Your Ref: OWPC14647
Our Ref: FG/198/16/PL 29-11-2016
Please ask for:
Andrew Wood

Demolition of existing house with erection of 2 storey building comprising of 8No.
residential 2 bedroom flats & associated external works
1 Sea Drive Ferring

Thank you for your internet representation made on 21st July 2017 which has been recorded as '**an objection**' with the comments as follows:

JOB: 1 SEA DRIVE, FERRING, WORTHING BN12 5HD
DWG: PROPOSED SITE PLAN

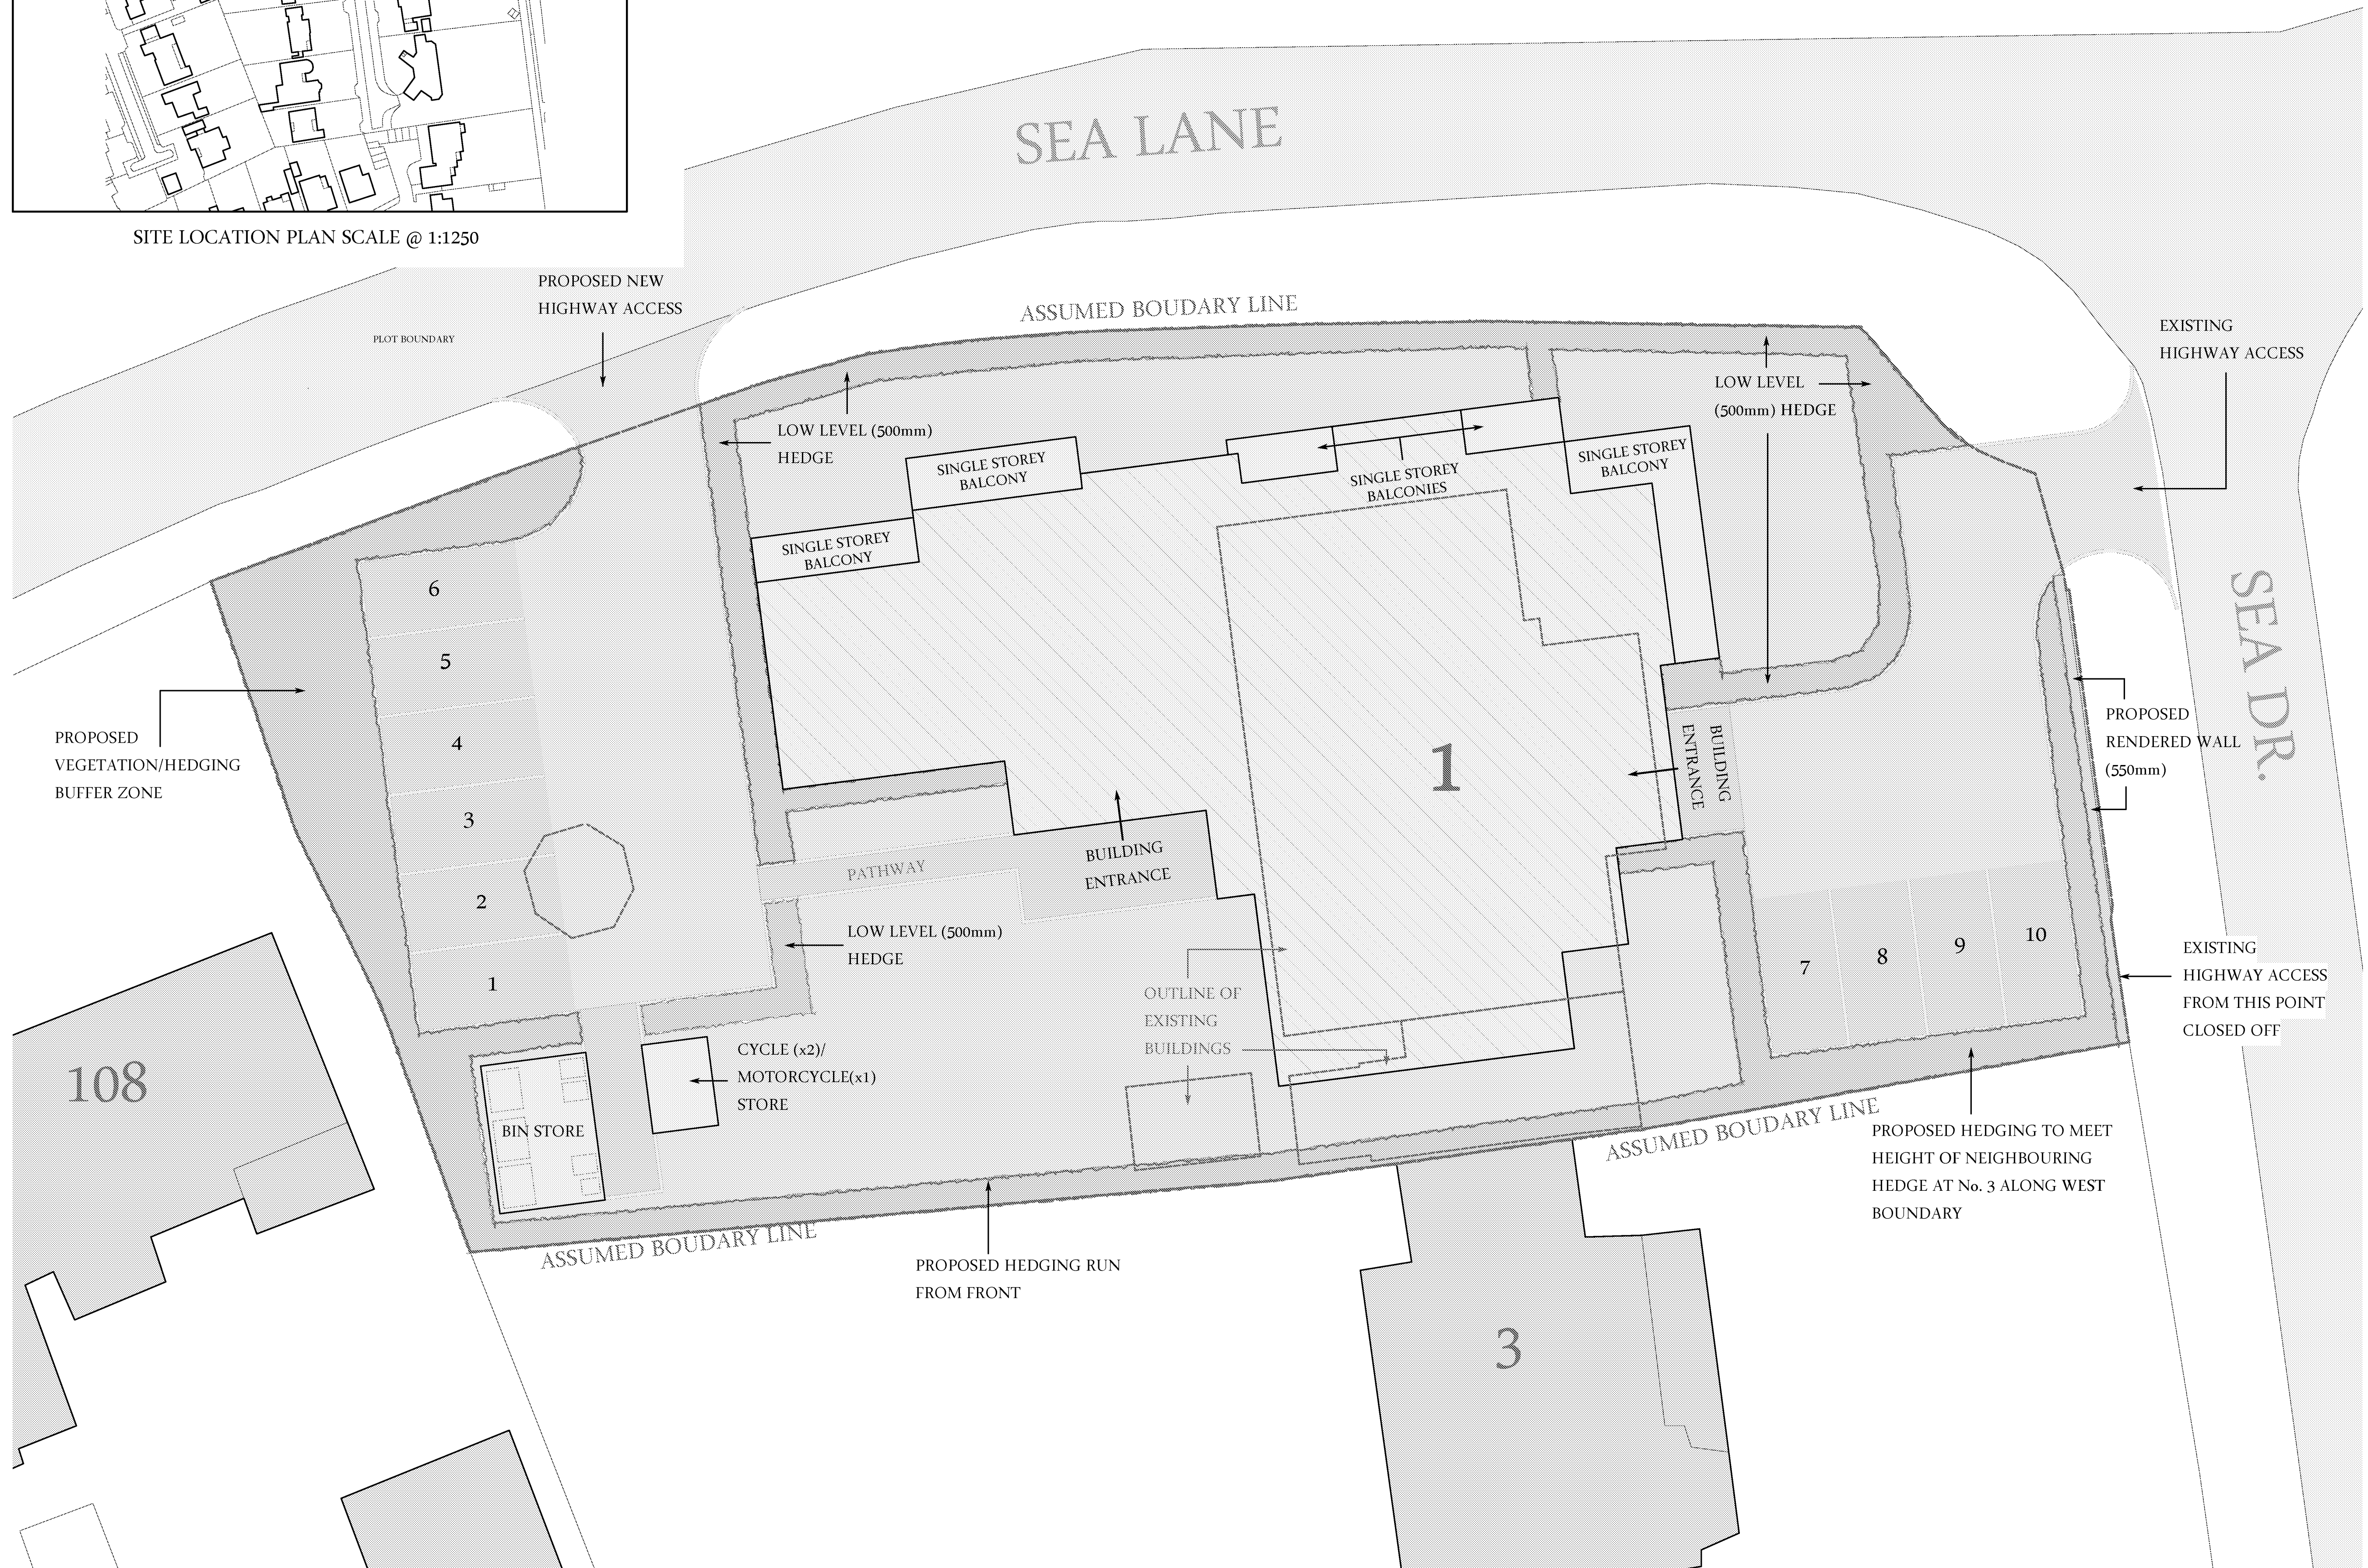
The recent revision of plans has done nothing to improve matters. Simply reducing the size of each parking space in order to comply with the requirement to accommodate more vehicles is not a practical solution. The plans show the amount of space available to manoeuvre cars is insufficient unless adjoining spaces are empty. The allocated widths do not allow for car doors to be opened. This is likely to cause stress to the potential owners of the spaces and damage to their vehicles as they try to squeeze the cars into the spaces and themselves out of the cars. Result will be increased vehicles parking on the sea front overnight and excluding other users during the day. The sea front parking should continue to be for locals and visitors using the beach and greensward - NOT for residential use.
